From: [Mau, Russell E \(DOH\)](#)
To: [Jeremiah Cromie](#)
Cc: [Holly Erdman](#); [Smits, Brenda M \(DOH\)](#); [Hayden, Kathryn E \(DOH\)](#)
Subject: RE: SP-22-00004 Willard - Notice of Application
Date: Friday, April 29, 2022 8:05:18 AM

The Department of Health (DOH) Office of Drinking Water (ODW) has the following comments or questions:

HAYBROOK FARMS - PHASE 2
 PART OF GOV'T LOT 3, SECTION 30, T. 18 N., R. 19 E., W.M.
 AND OF THE E 1/2 OF SECTION 25, T. 18 N., R. 18 E., W.M.
 KITTITAS COUNTY, WASHINGTON

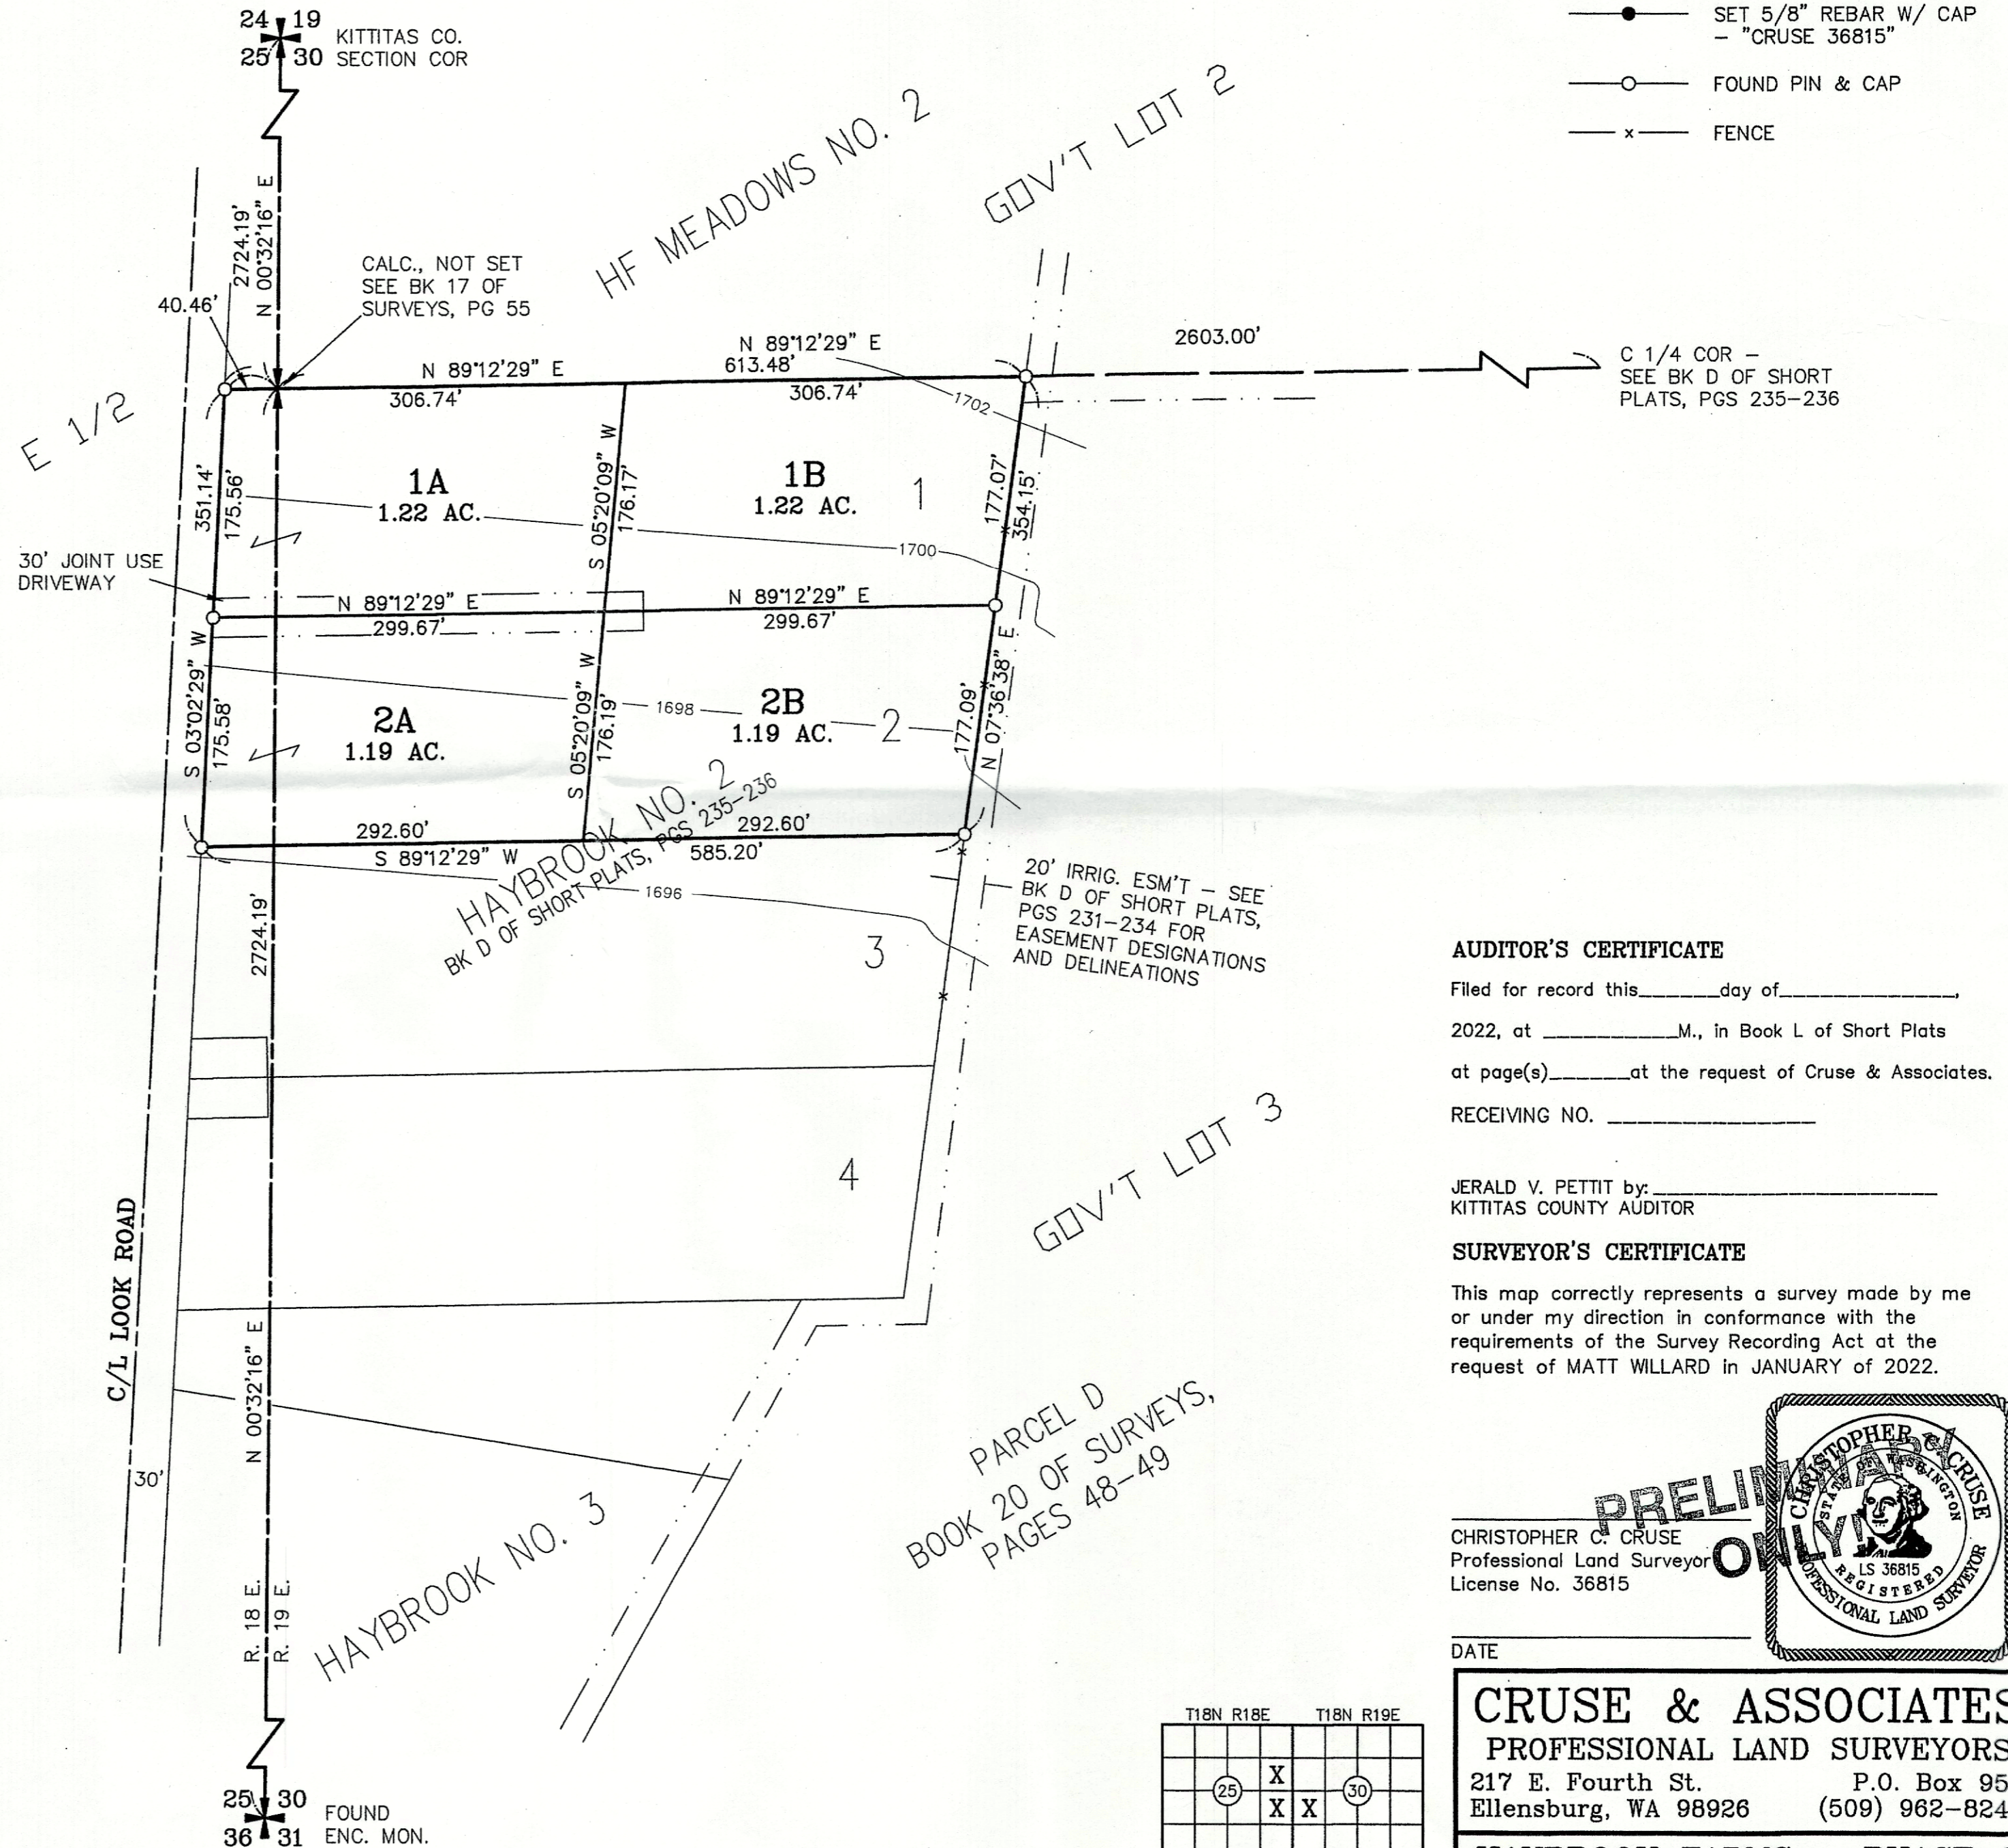
- The applicant indicates both the property location is within the City of Ellensburg's Urban Growth Area and "All proposed parcels will be on their own community water system". DOH ODW wonders why the applicant didn't consider connecting to the City's water system?
- Also, per the above bullet item, for four (4) parcels (with a single home per parcel), a separate public water system most likely would be a Group B water system due to the number of connections, four (4). For a Group B water system, Kittitas County Health has exclusive administrative authority and responsibility.
- DOH ODW does concur that the use of groundwater should be considered as a collective because it is a "project" – if warranted, please contact the State of Washington Department of Ecology for more guidance.
